Roy & Wendy Tillman
32, Esplanade Grande
The Esplanade
Bognor Regis
West Sussex
PO21 1NY

Your Ref: OWPC14833
Our Ref: BR/194/17/PL 30-06-2017
Please ask for:
Richard Temple

Demolition of the existing Foreshore office & decommissioning of existing underground toilets. New purpose built unisex toilet block including urinals, baby changing facilities & accessible WC, plus a separate beach office with public information point & first aid facilities. All located on the existing seafront promenade.

Promenade Opposite Clarence Road The Esplanade Bognor Regis

DRAWING
Proposed Toilet Elevations

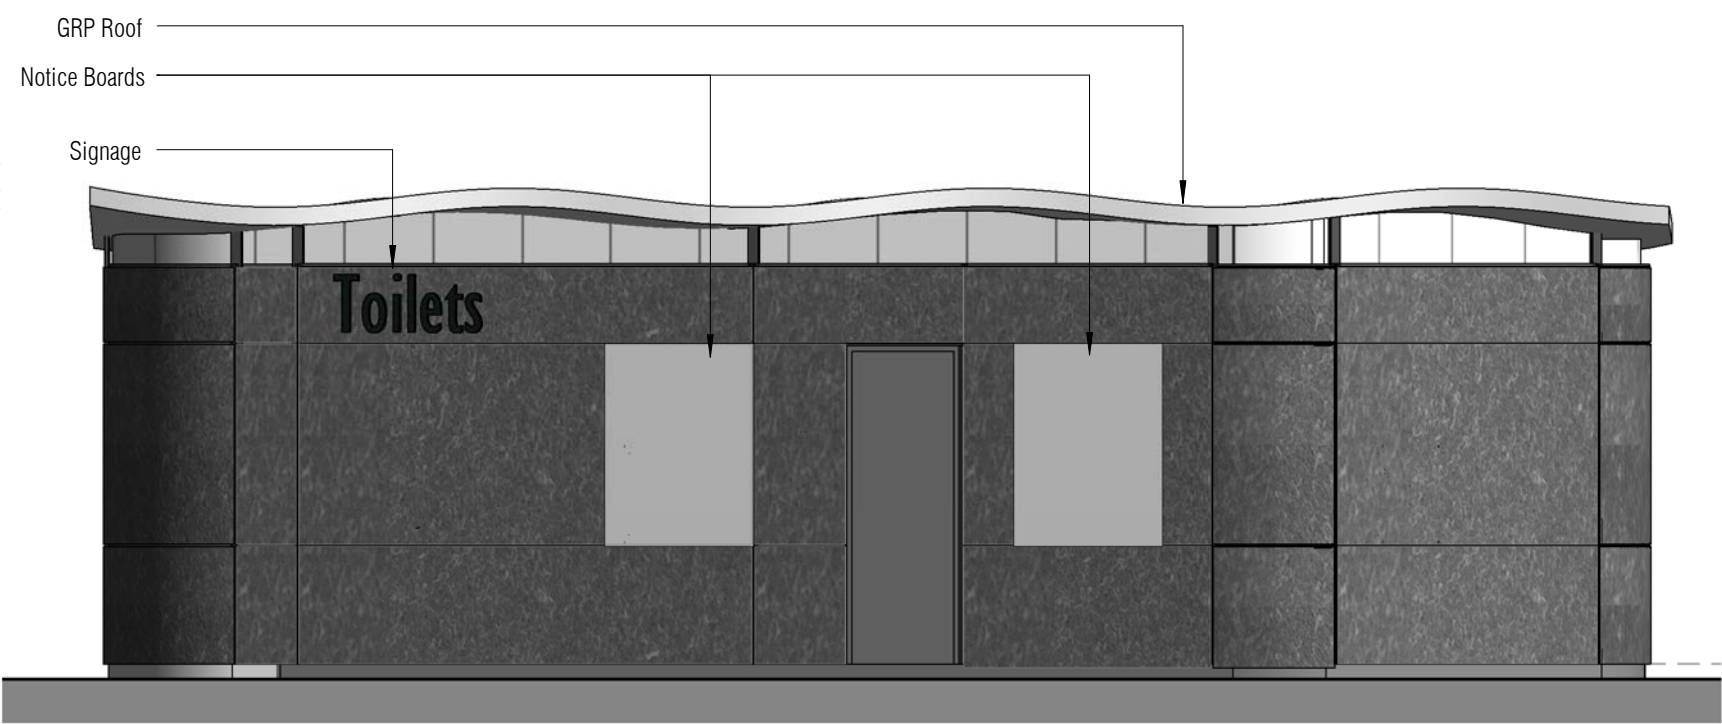
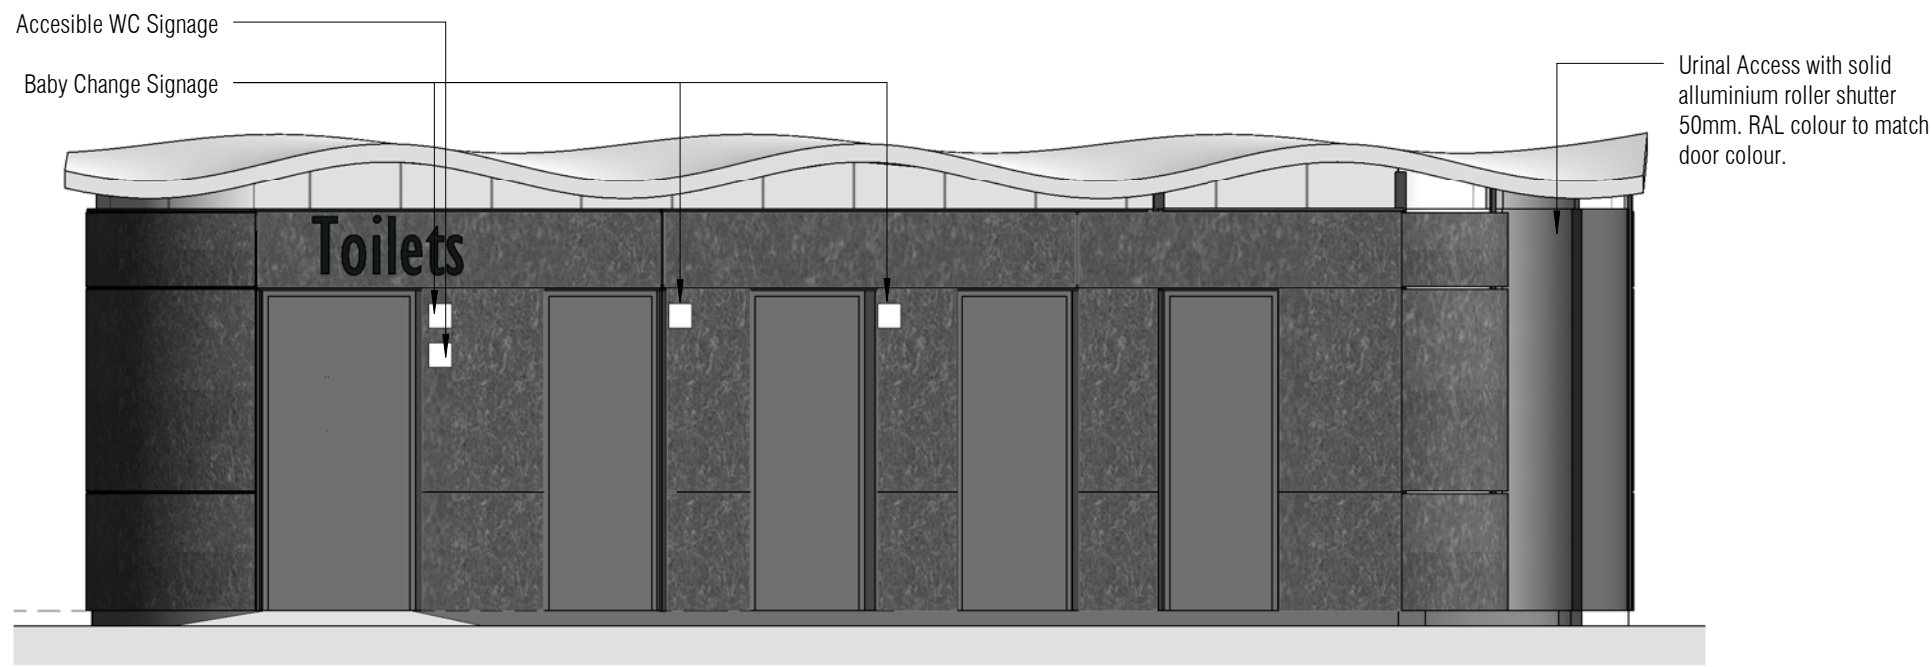
In our opinion, it is utter madness to locate an above ground toilet block with its doors facing directly opposite and towards a residential apartment block so that residents have to view persons entering and leaving the toilets all day long. The design is seriously flawed and we would question why it is that the existing underground toilets could not be refurbished at a lesser cost and with the addition of above ground CCTV to monitor activity in the area. The existing foreshore office is a far nicer looking structure than the proposed replacement. Why do Councillors want to waste money by replacing it? Perhaps they would like a modern toilet block situated directly opposite their homes. We don't think so! Please reconsider this plan and locate it where it does not visually assault the senses.
